**Albuquerque Studios Master Plan
Development**

Traffic Impact Study

September 13, 2021

The following two sections in the Executive Summary list agency comments received on the draft TIS submission along with responses provided for this final TIS.

Figure 17 summarizes the recommendations for traffic control and lane configurations for the Implementation (Buildout) Year.

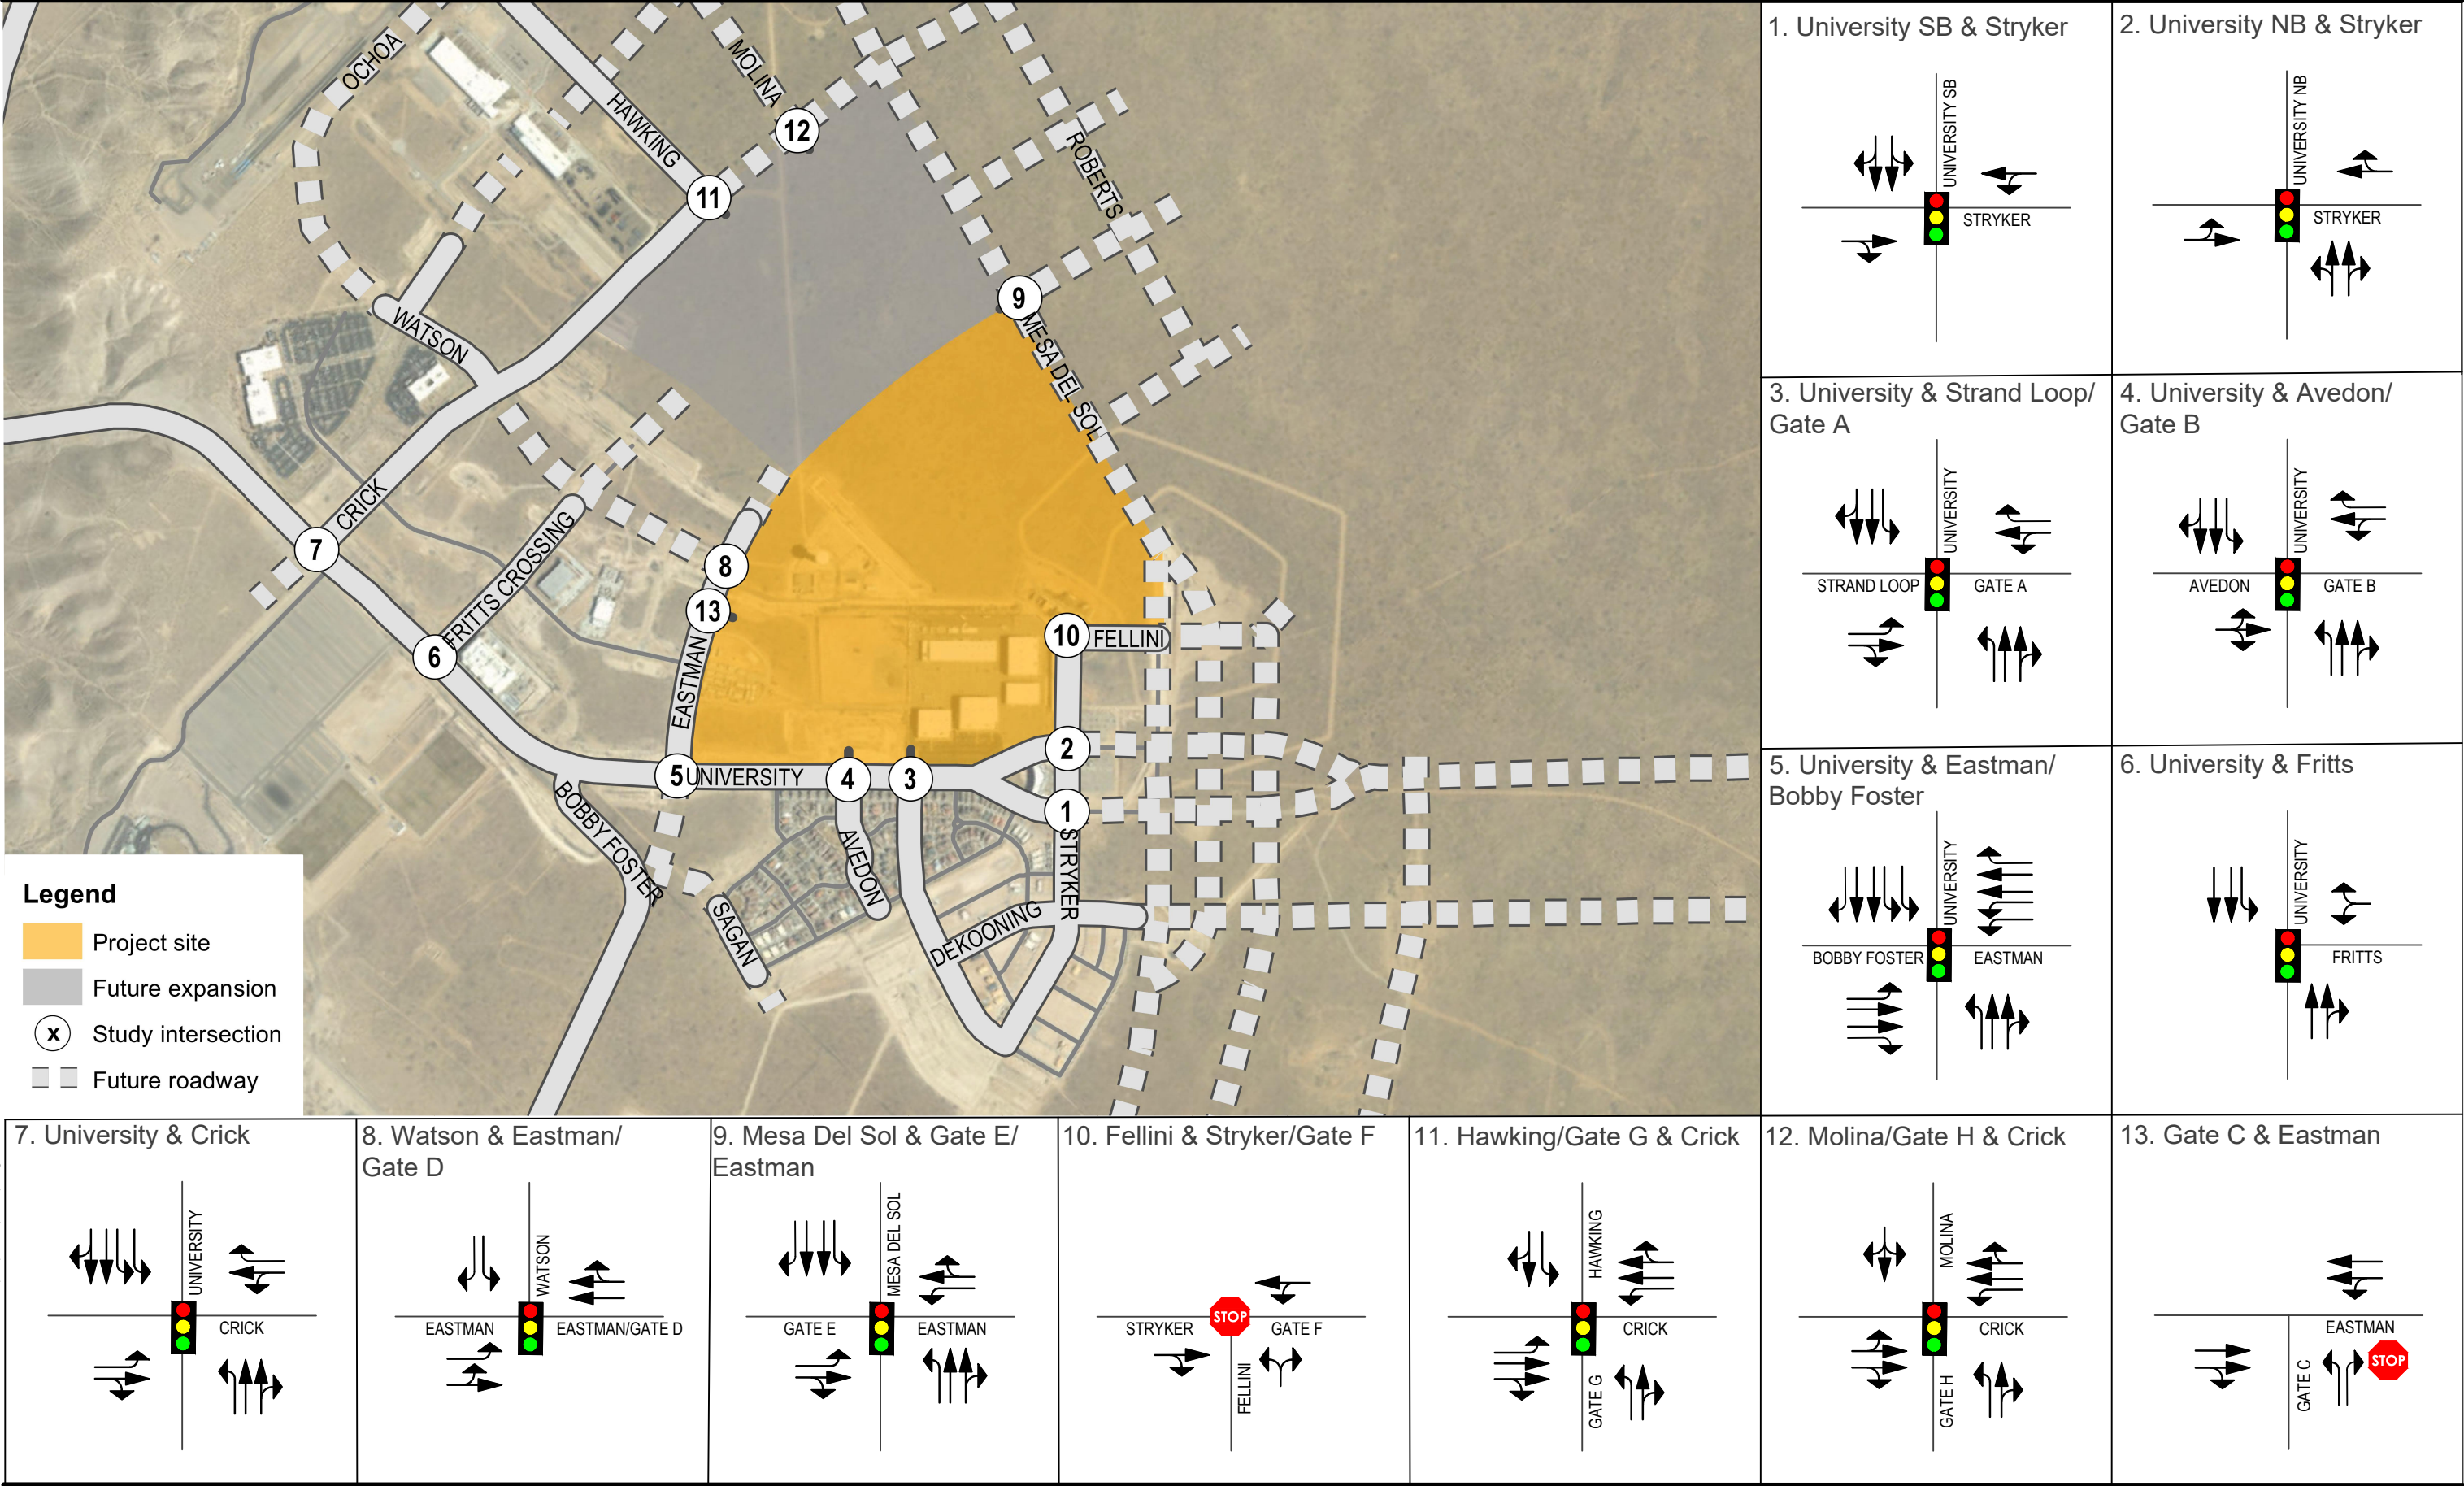
4. Evaluate Eastman Crossing Ave. /University Blvd. intersection operations with Montage 6 and athletic fields traffic. Provide the intersection LOS and a traffic signal warrant analysis for the Netflix build year.

8. If a traffic signal at University Blvd. and Crick Ave. or other intersection are anticipated a traffic signal warrant will need to be conducted. Alternative intersection control should be considered along with the traffic signals.

There are recommendations for signalized intersection at the following intersections in future years. Could any of these be a modern roundabout?

University and Eastman (#5).

University Blvd and Crick (#7)

This intersection was analyzed (see response above) for the implementation year and horizon year conditions.

A traffic signal is recommended for consideration when one (or more) of the following "Triggers" occur

- 1. Mixed-use development growth west of the site occurs.*
- 2. Athletic Facilities/Complex Improvements (Bernalillo County)*
- 3. Bobby Foster Re-alignment into Eastman Drive*
- 4. North Periphery build-out or other development northeast of University Boulevard and Eastman Ave that will contribute additional Horizon Year traffic flows as this intersection*

A Signal Warrant Analysis (SWA) was conducted for future conditions (Implementation Year). Warrants 1,2,3 (8-hour,4-hour, and Peak Hour) were satisfied for the intersection.

University Blvd and Crick Ave. was analyzed in the study. This intersection is recommended for Two-Way-Stop-Control (TWSC) for the implementation year and for a traffic signal for the horizon year, assuming continued growth consistent with the Level B Master Plan.

Modern Roundabout Analysis: This intersection could potentially operate at an acceptable LOS as a roundabout. It is recommended that it be re-considered in the TIS conducted for the Athletic Complex improvements once traffic projections are forecasted for this development. There are several considerations such as special event traffic and peak hour traffic scenarios for consideration. Impacts to adjacent corners of the intersection and geometric footprint of the roundabout should be considered in the decision to proceed with a roundabout traffic control type.

A Signal Warrant Analysis (SWA) was conducted for future conditions (Implementation Year). The applicable warrants 1,2,3 (8-hour,4-hour, and Peak Hour) were not satisfied for the intersection.
